WEST SUSSEX COUNTY COUNCIL CONSULTATION

TO:	Arun District Council FAO: Finlay Gardner
FROM:	Highways, WSCC
DATE:	19/04/2021
LOCATION:	29 Highcroft Crescent, Bognor Regis, PO22 8DH
SUBJECT:	BR/86/21/PL Convert existing bungalow in to 1 No. 3 bed bungalow and 1 No. 2 bed bungalow. This application is in CIL Zone 4 and is CIL Liable as new dwelling.
DATE OF SITE VISIT:	N/A
RECOMMENDATION:	Advice
S106 CONTRIBUTION TOTAL:	£N/A

sheet 1 of 3

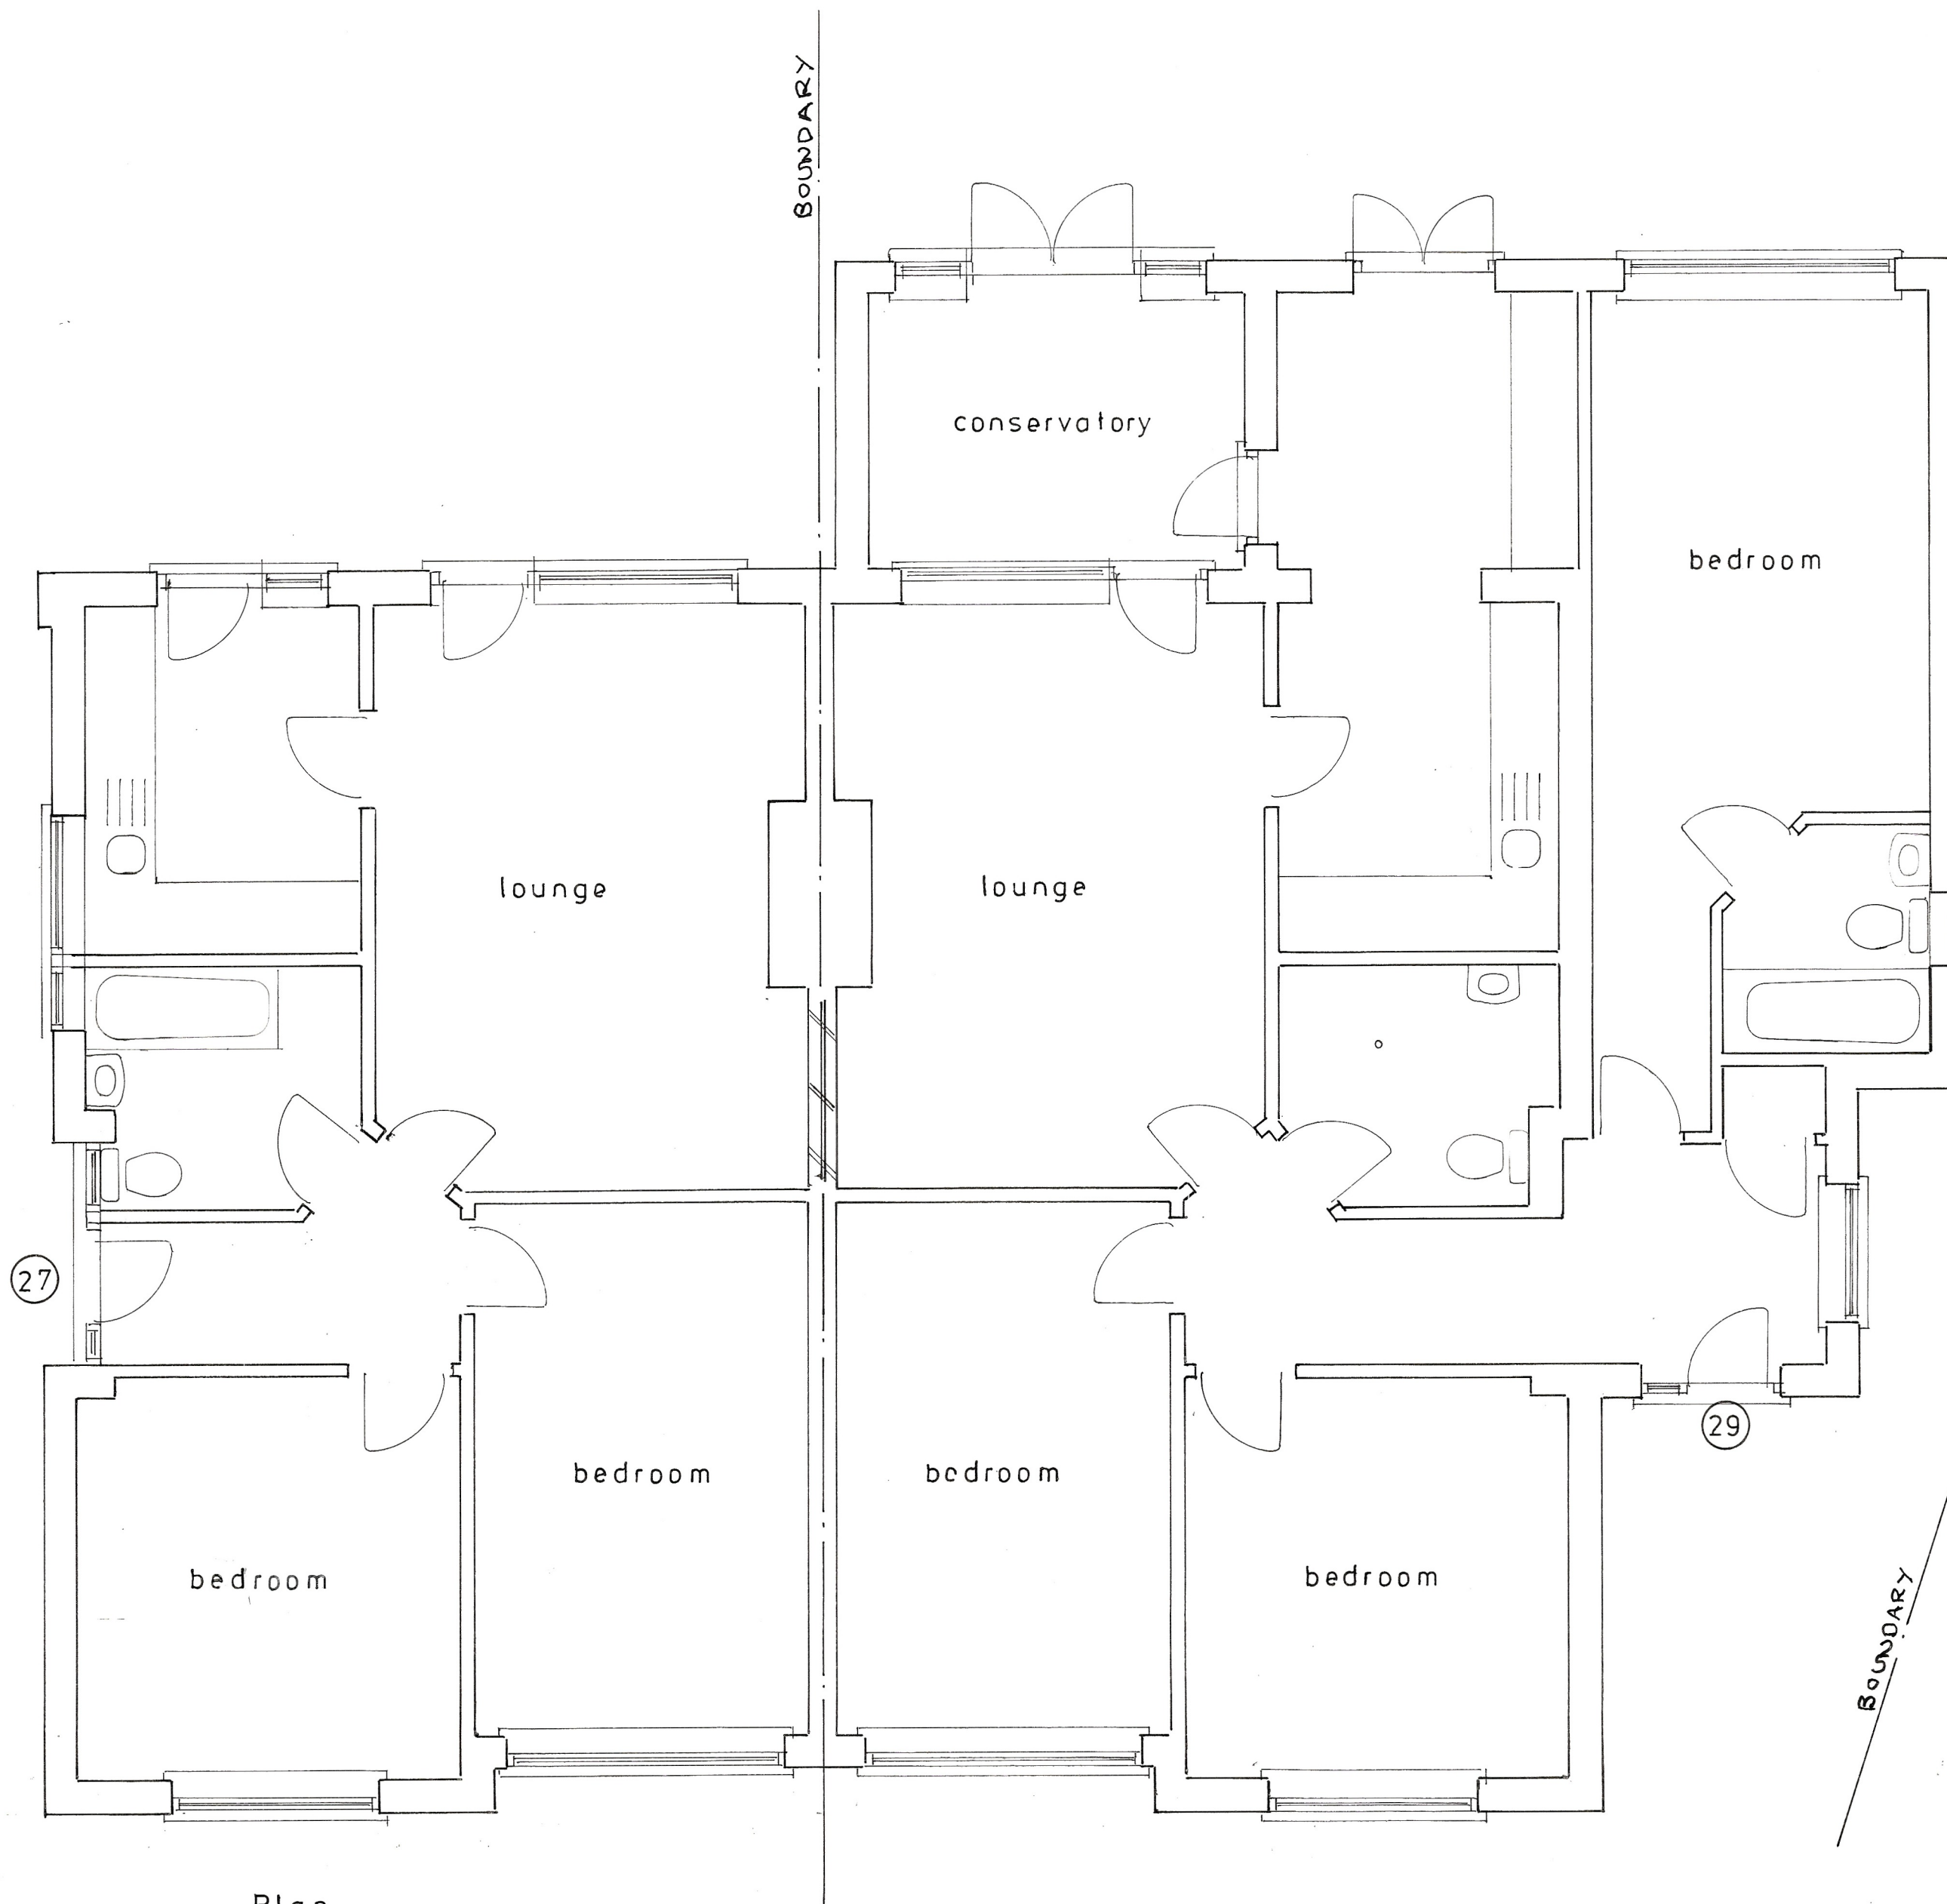
The applicant proposes to utilise the existing driveway for vehicular parking. Under Arun Parking Standards, a development of this size in this location would require three car parking spaces. From inspection of the plans, there appears to be sufficient space within the driveway for this parking demand to be accommodated.

On-site turning does not appear achievable, so vehicles may have to exit the site in a reverse gear. However, this is the existing arrangement, which has operated with no known highway safety concerns.

The applicant has not demonstrated cycle parking provision. Cycling is a viable option in the area and the LHA would like to see cycle parking being implemented, in accordance with WSCC and Arun Parking Standards. The inclusion of secure and covered cycle parking provision helps promote the use of sustainable alternative modes of transport to the private car.

No part of the development shall be first occupied until the car parking has been constructed in accordance with the approved site plan. These spaces shall thereafter be retained at all times for their designated purpose.

No part of the development shall be first occupied until covered and secure cycle parking spaces have been provided in accordance with plans and details to be submitted to and approved by the Local Planning Authority.
